Application for a Non-Material Amendment Following a Grant of Planning Permission

Construction of single storey dwelling

22/00346/FUL

**ELEVATIONS
AS PROPOSED**

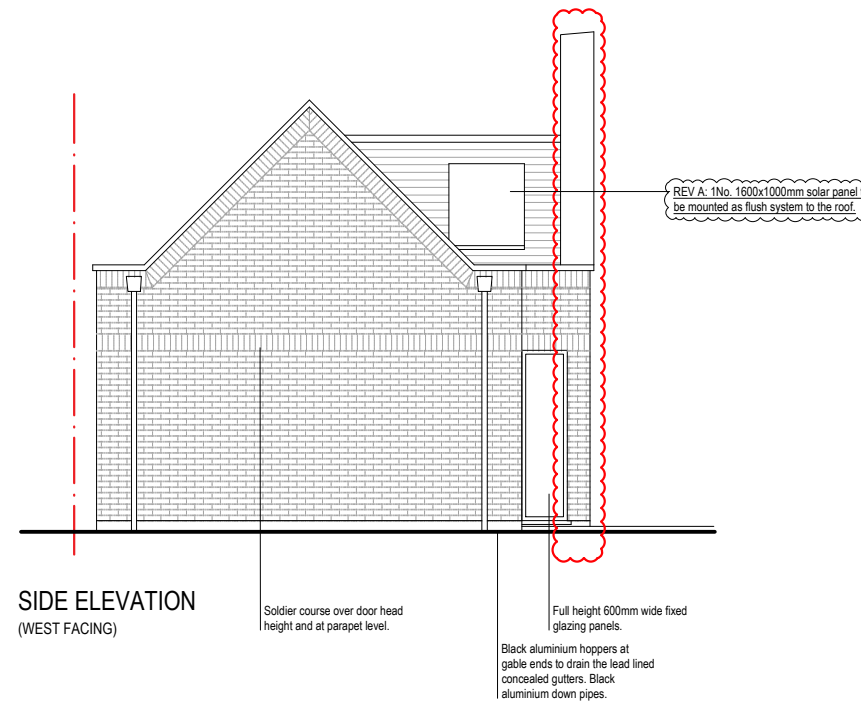
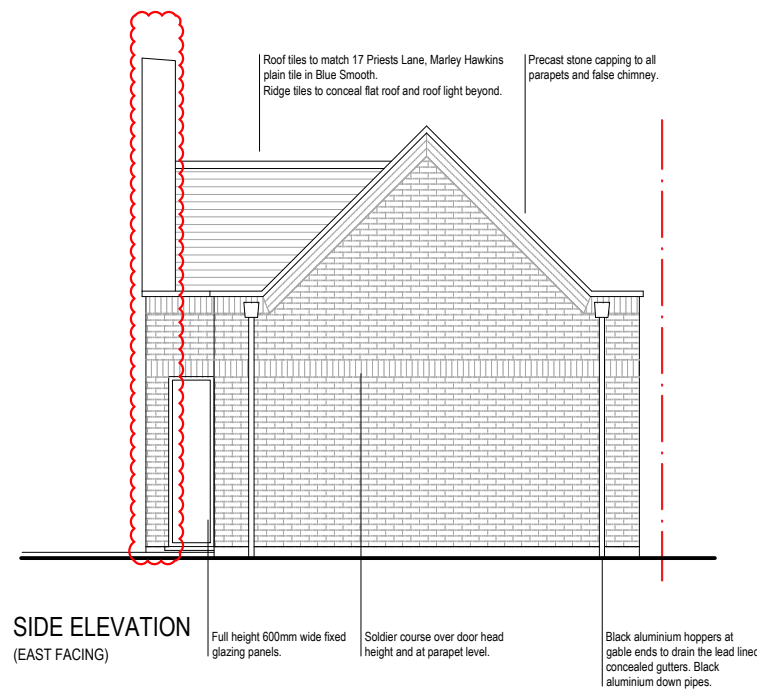
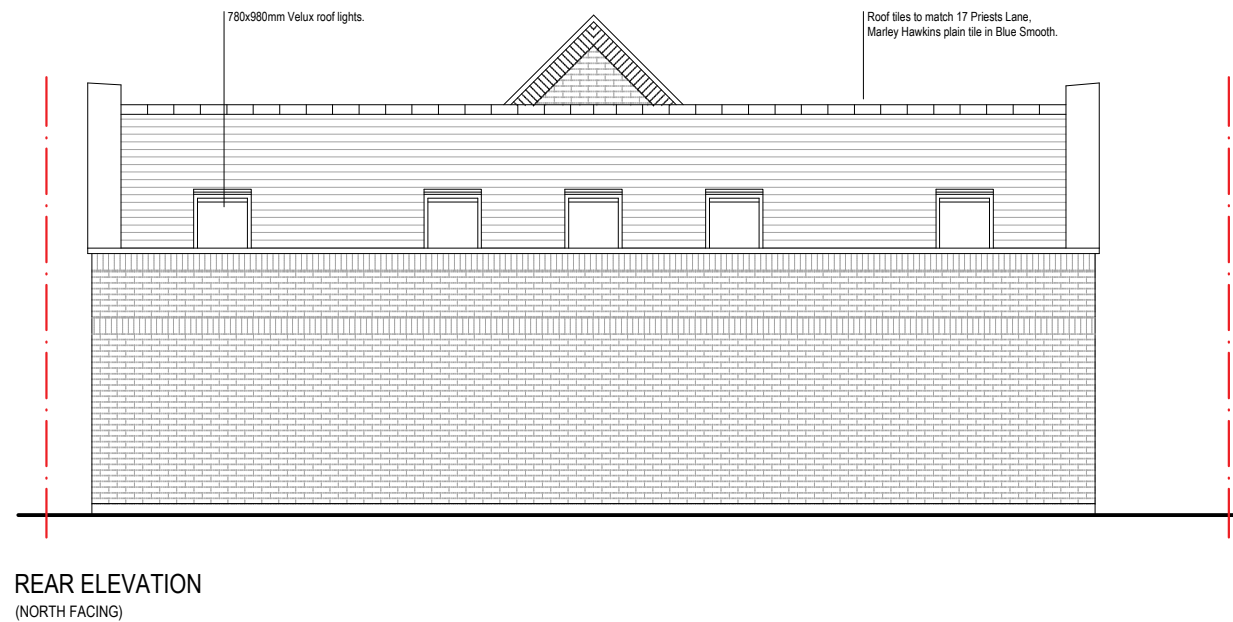
Omission of chimney
